From: [Jordan Bovee](#)
To: [Zach Torrance-Smith](#)
Cc: [Amelia Stanger](#); SEPA@dahp.wa.gov
Subject: Re: SX-26-00010 Easton River LLC - Notice of Application
Date: Wednesday, July 8, 2026 5:04:26 PM

This review is in response to the permit application SX-26-0010 from Easton River LLC for an additional septic system.

TO: All Staff
FROM: Public Works Plan Review Team
DATE: July 13, 2026
SUBJECT: SX-26-00010 Easton River LLC

EXHIBIT MAP SHOWING EXISTING AND PROPOSED SEPTIC CONDITIONS

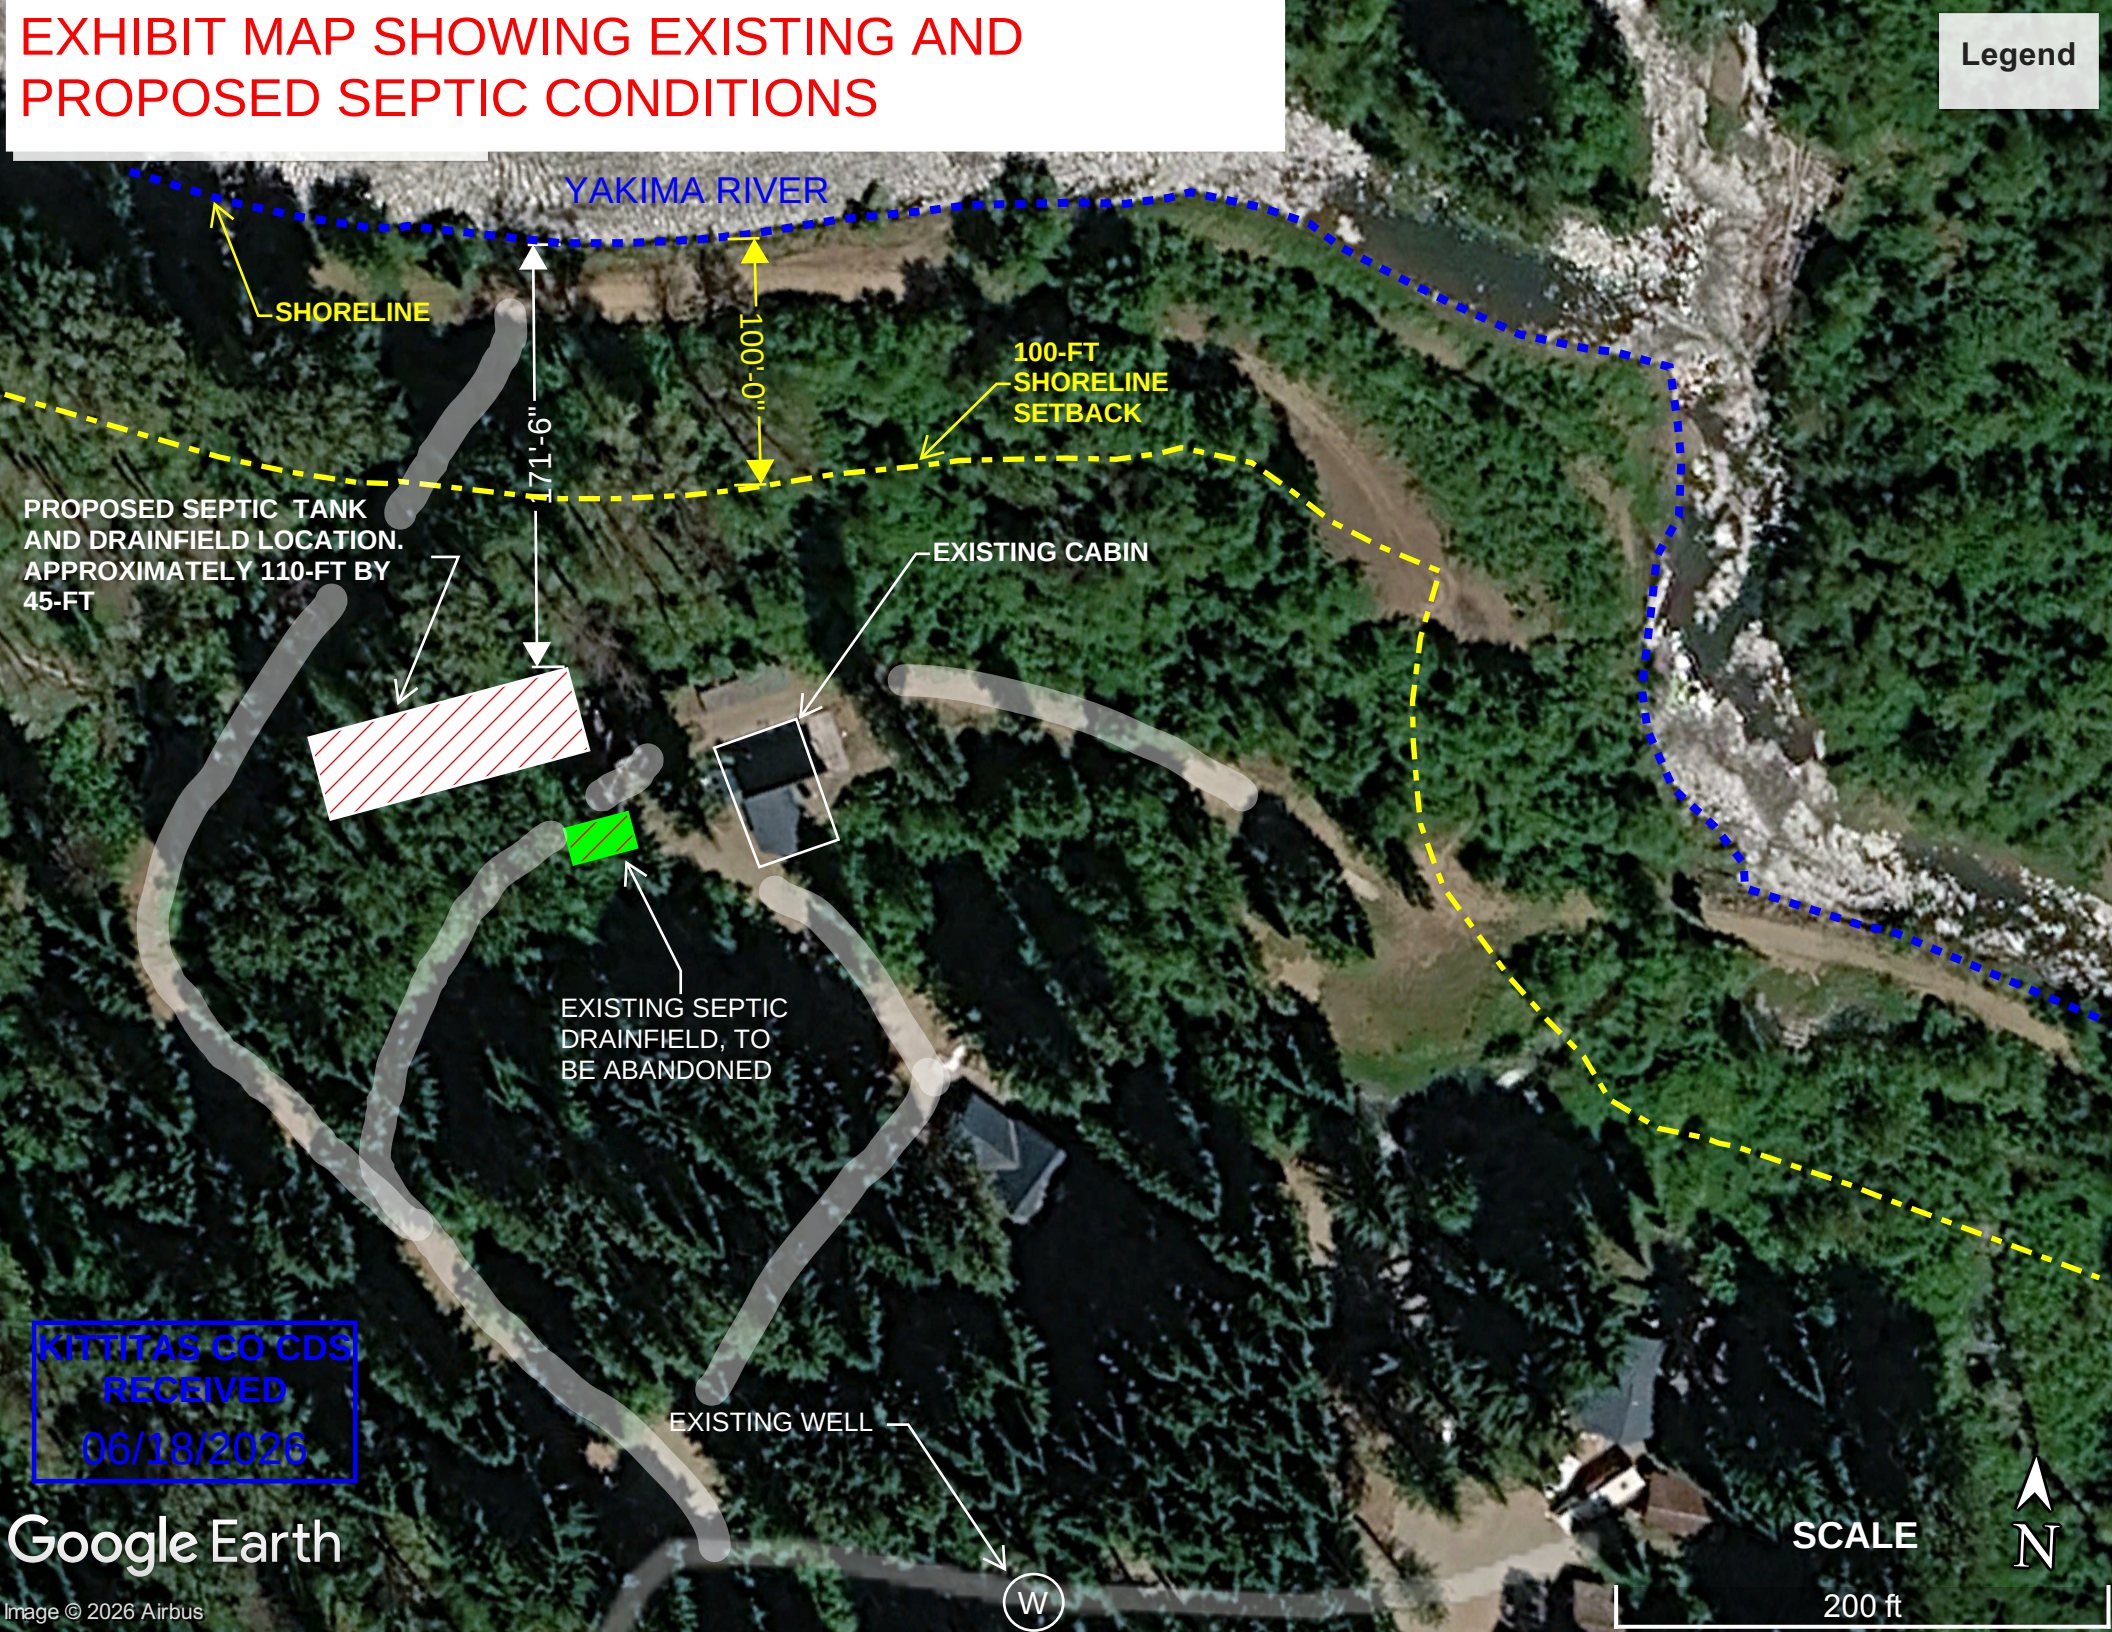
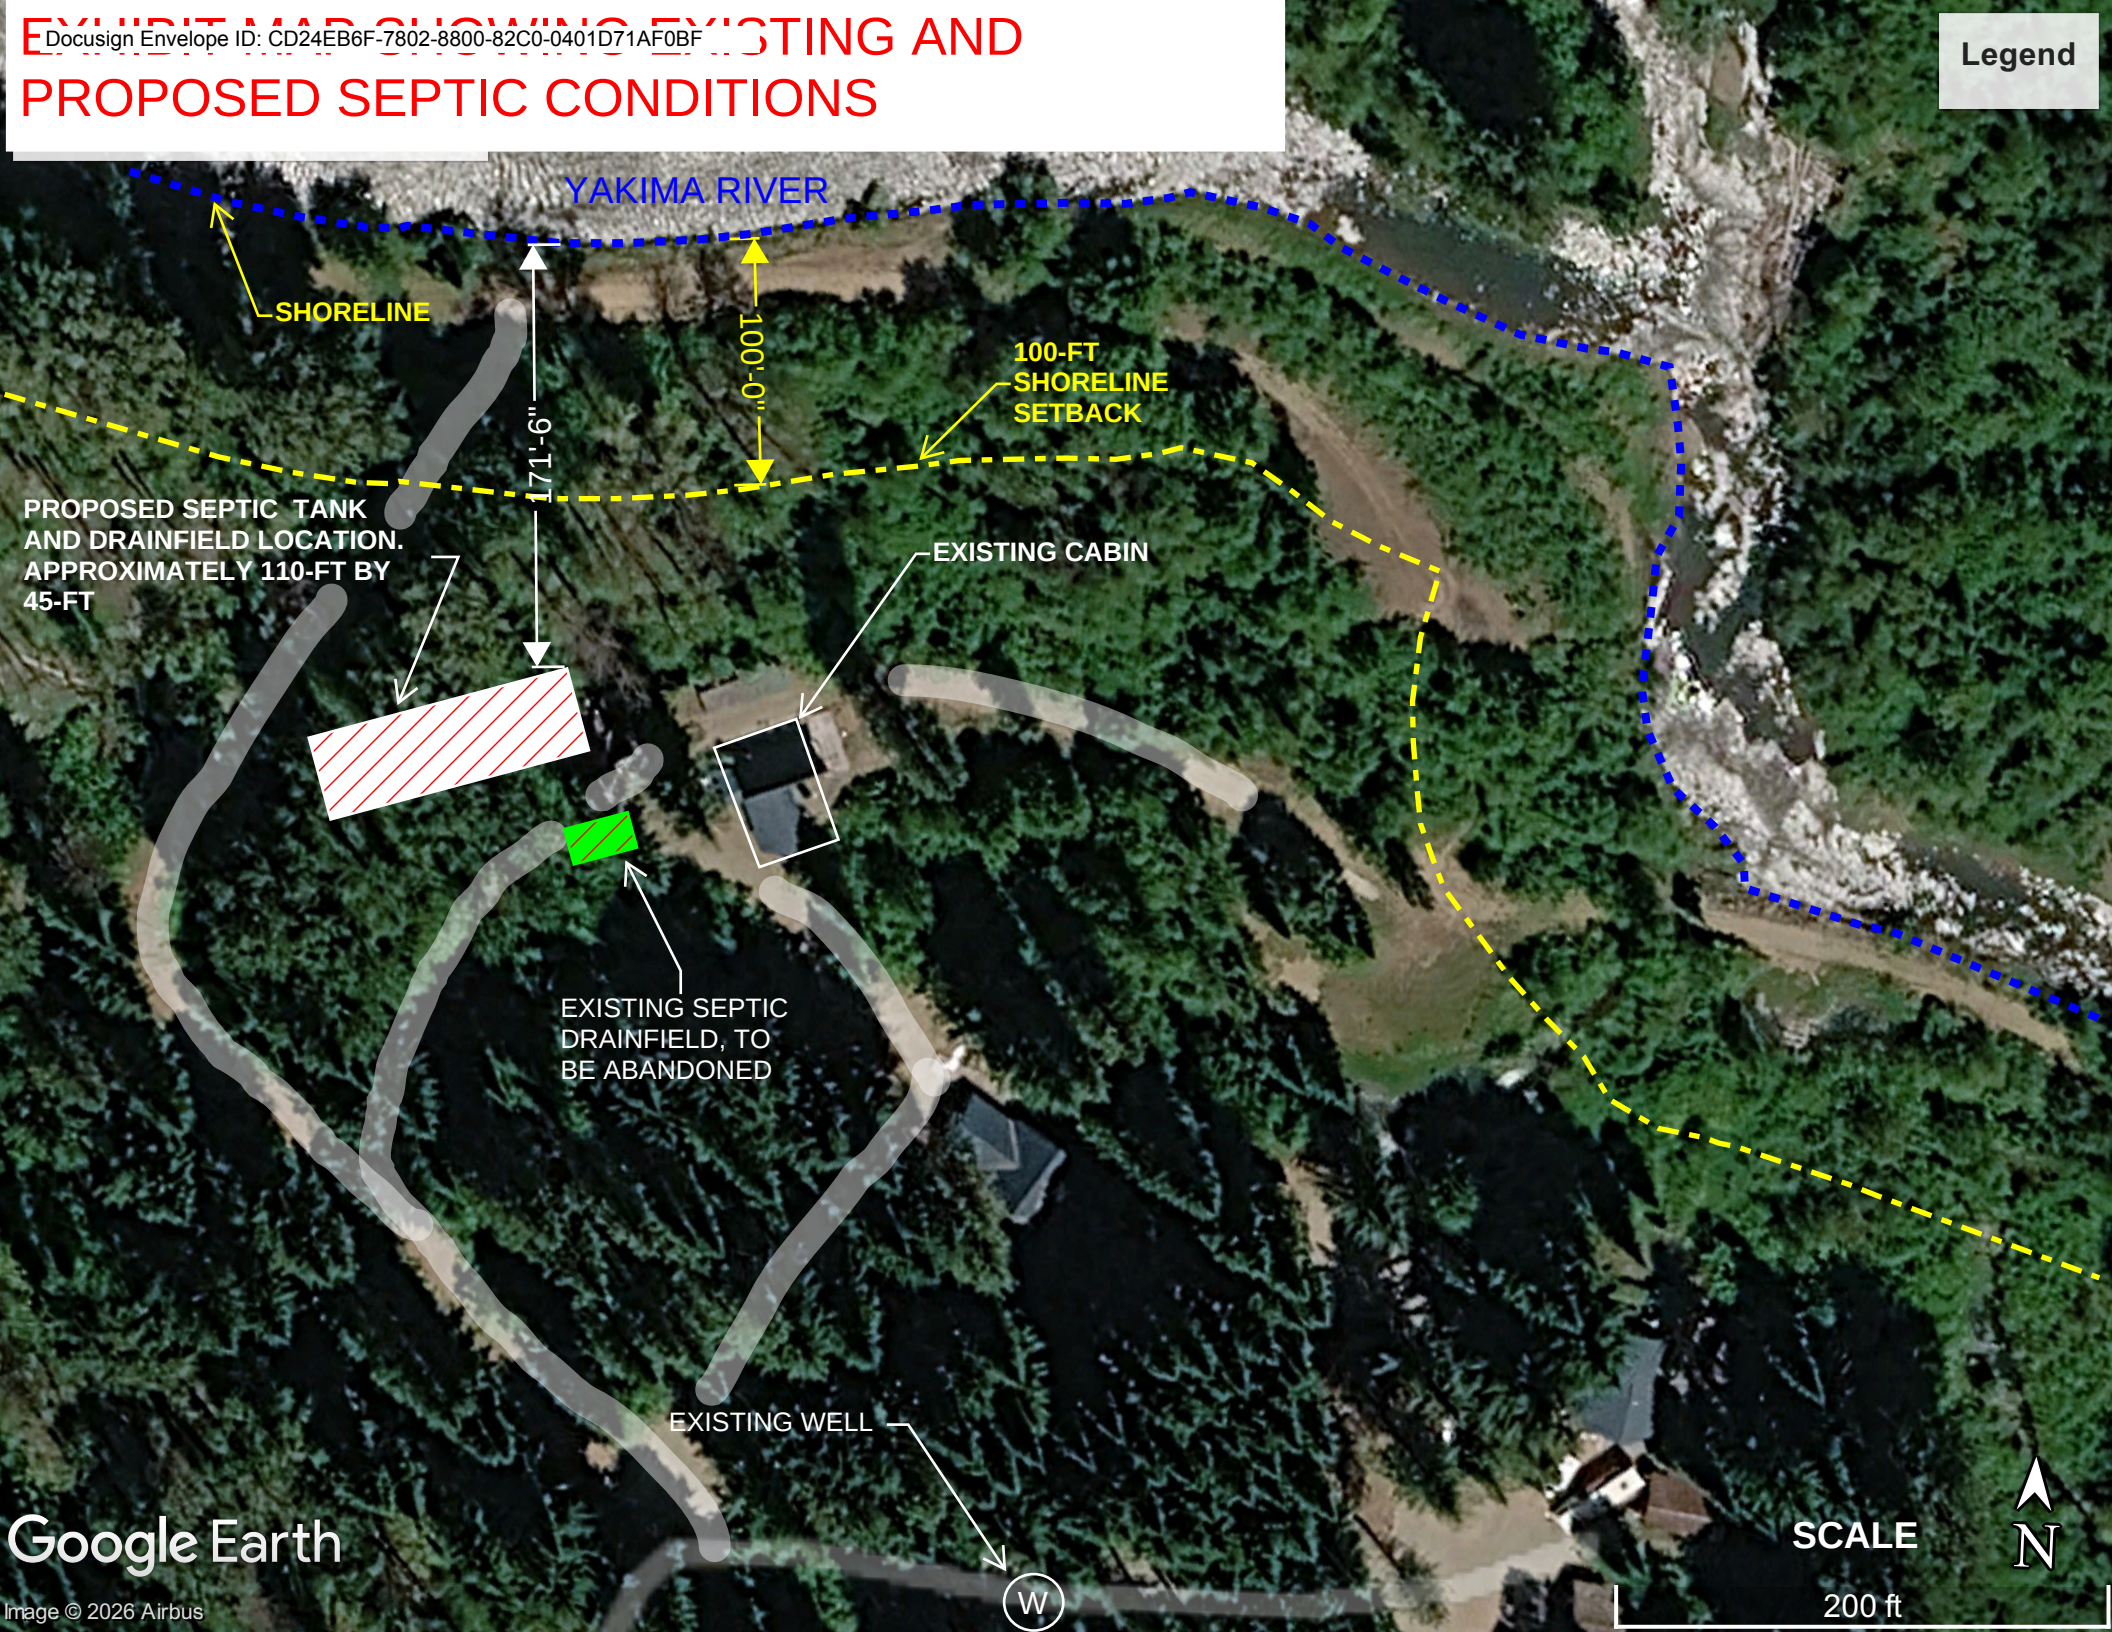
Site plan shows proposed drainfield and septic tanks maintaining the respective 100' and 50' setbacks from surface water. No comments pertaining to the project.
